DRB Application No.: 09DRB-70101 Project # 1007008  
Project Name: Graceland Acres Addn.  
Agent: Darren Sowell Architects Phone No.:

**DRB Comments**

**PROJECT # 1007008**

**Date:** Feb. 2, 2009  
**To:** Jack Cloud, DRB Chair  
**From:** Carol Toffaleti, Staff Planner, Development Review, 924-3345  
**cc:** Craig Calvert, DSA Architects  
**Subject:** Project #1007008 – JLM Auto Sales at Candelaria/Arno  
07EPC-40104 Zone Map Amendment, 08EPC-40086 Site Development  
Plan for Building Permit

**LANDSCAPE PLAN**  
1" = 20'

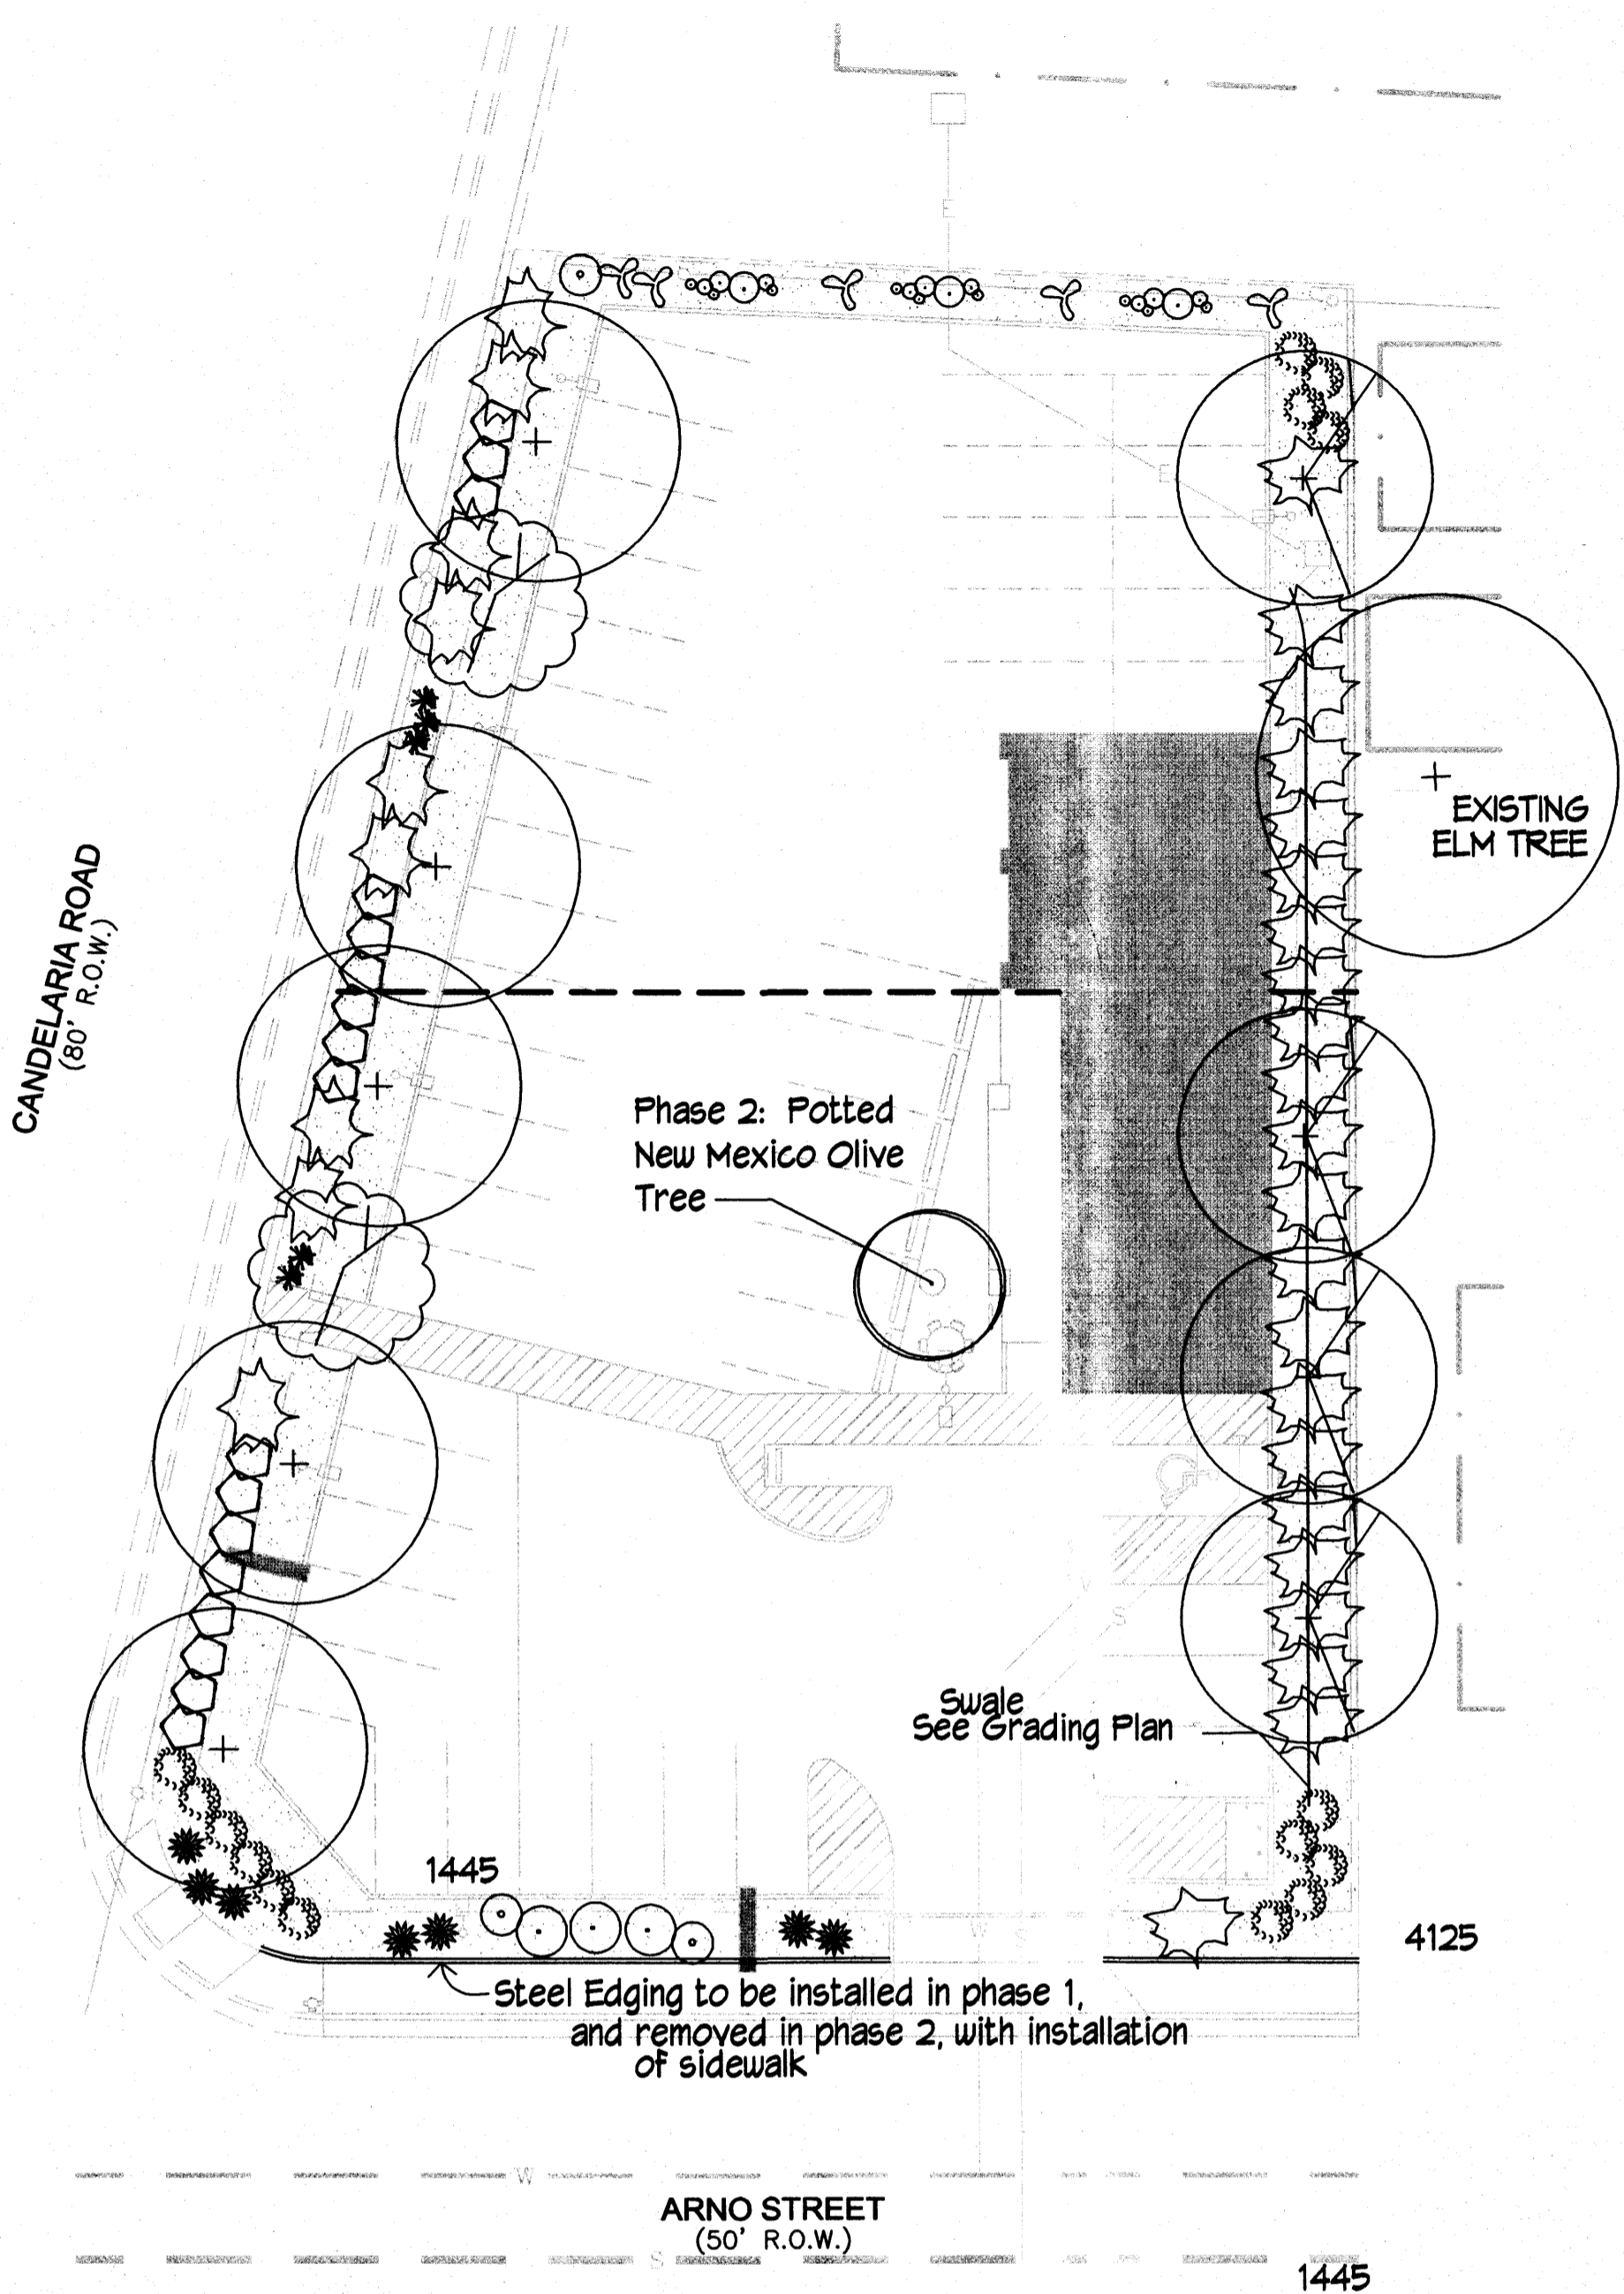
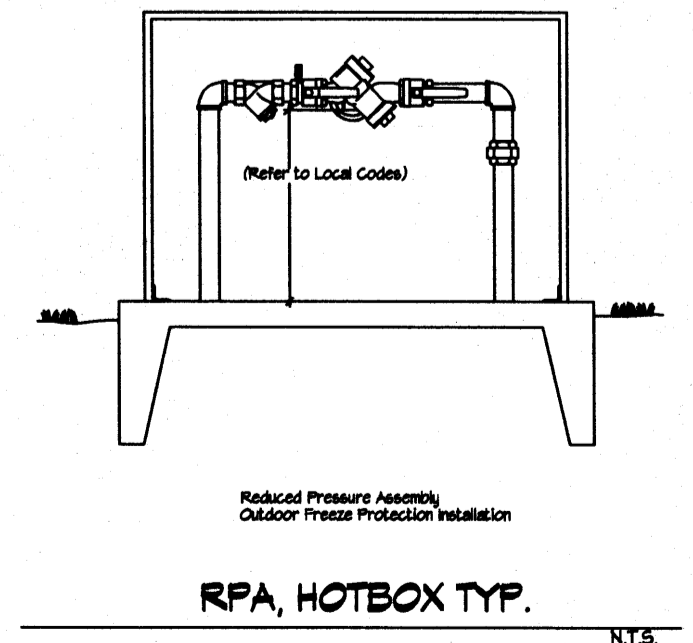
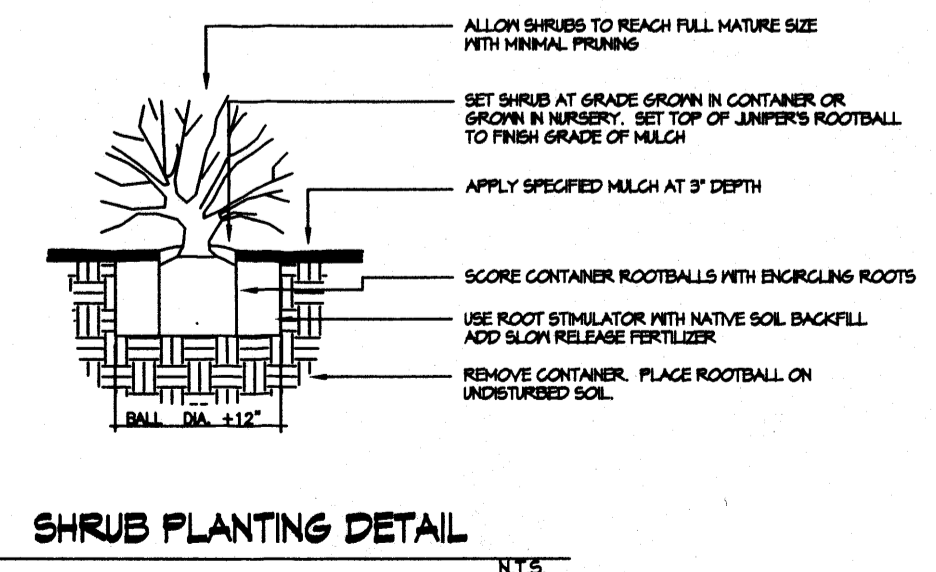
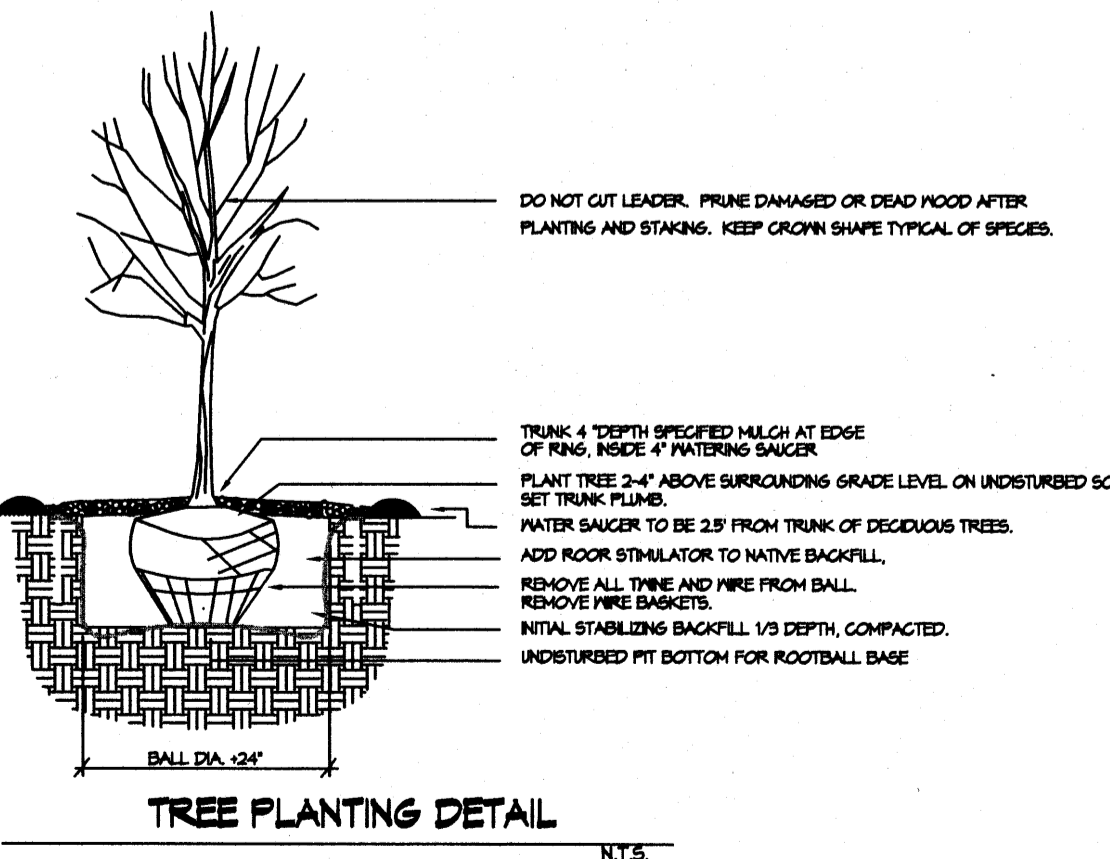
The 6 ft high screen wall begins at a distance of 24 ft from the northeast corner of the perimeter fence line. All the species along this 24 ft stretch must be evergreens that are 2.5' high at planting (to screen the parked cars) and not reach a mature height of more than 3' (to accommodate the neighboring resident). Honeysuckle vines and 1 gallon size Hawthornes are unlikely to comply with one or the other requirement. For clarity, the landscape plan should also indicate these size and distance requirements.

The spacing of the trees must be 75% of the mature canopy per buffer landscaping regulations. An additional Chitalpa or similar is required east of the neighbor's elm.

- d & e. Potted shade tree – A single tree is acceptable to meet these conditions. However, replace the planter with a tree well and grate so the tree can benefit from infiltration of runoff into the adjacent vehicle display area.
- f. Correct size of Yucca pendula to 5' height x 2' spread; Yucca parviflora to 3' h x 4' s. Adjust calculations accordingly. (Also, note that the building footprint is 2160 sf.)

Eliminate the bold line through the middle of the landscape plan.

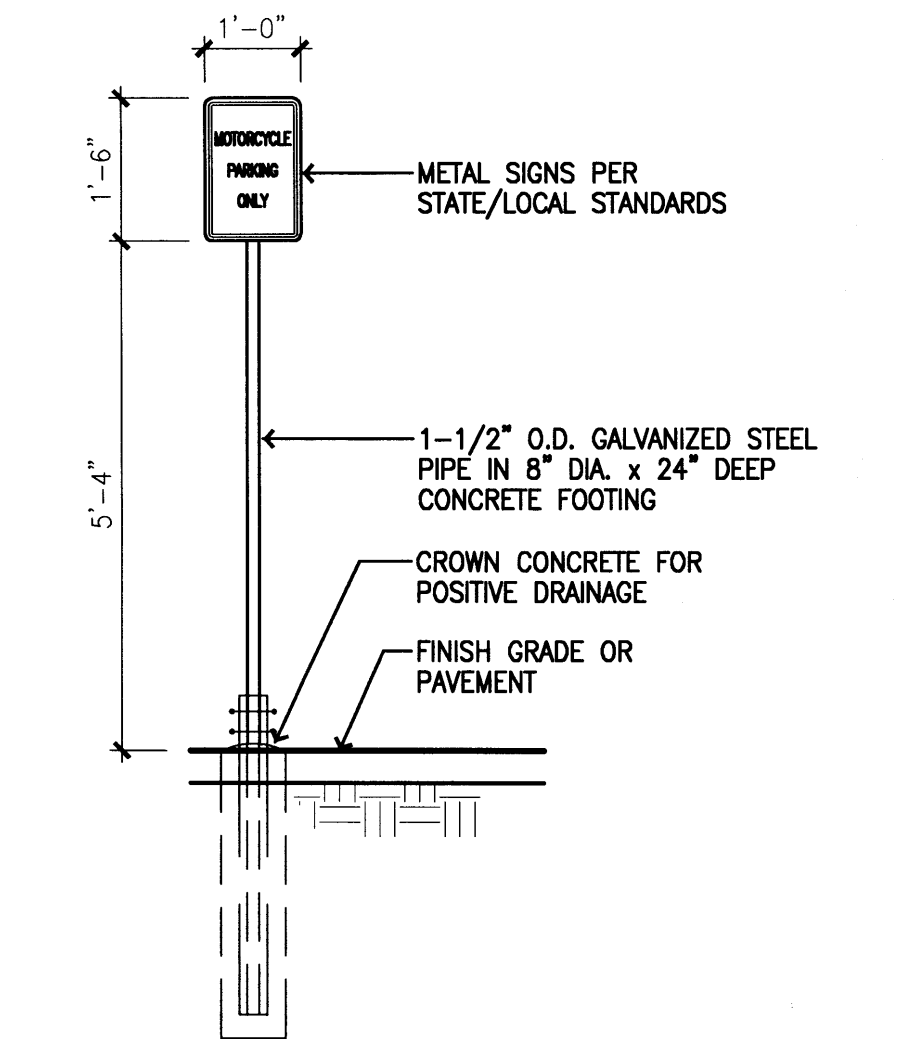
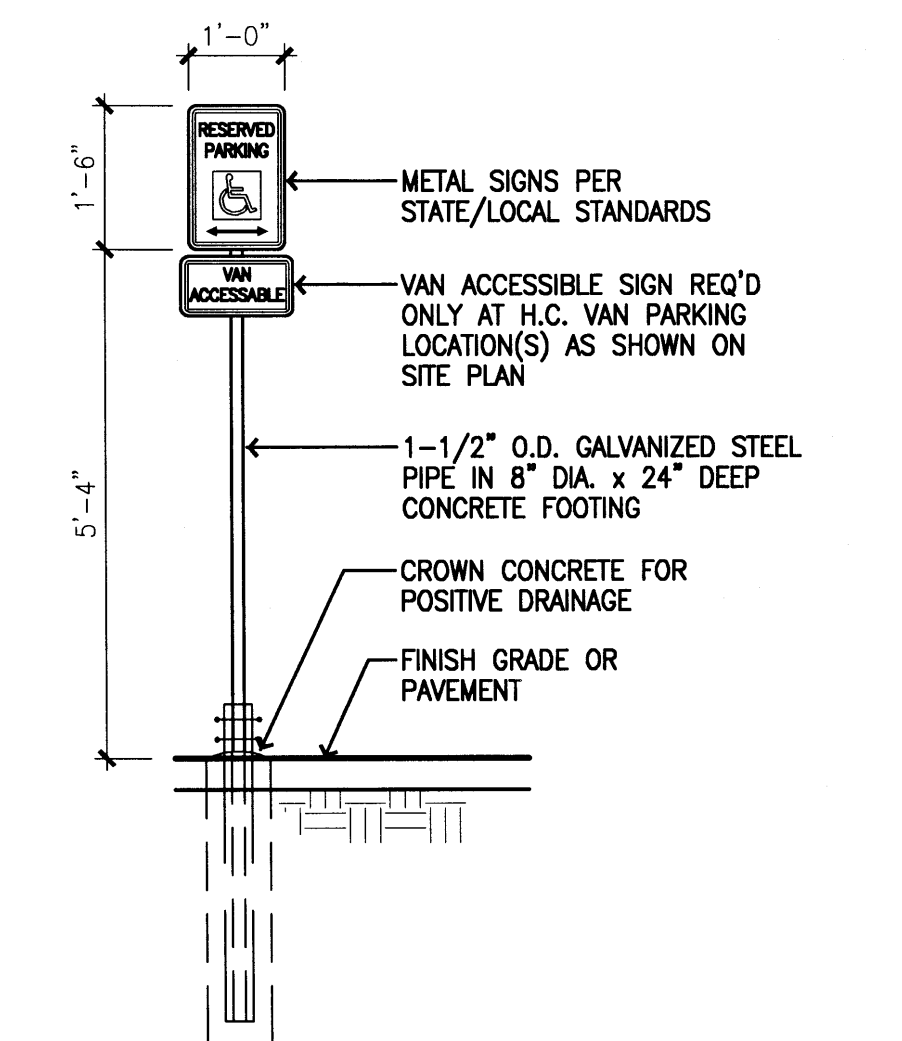
- b. Signage – In Note A on sheet A201, under Size, delete first line “250 f ...arterial”. This C-2 regulation does not apply to the zoning of the site.
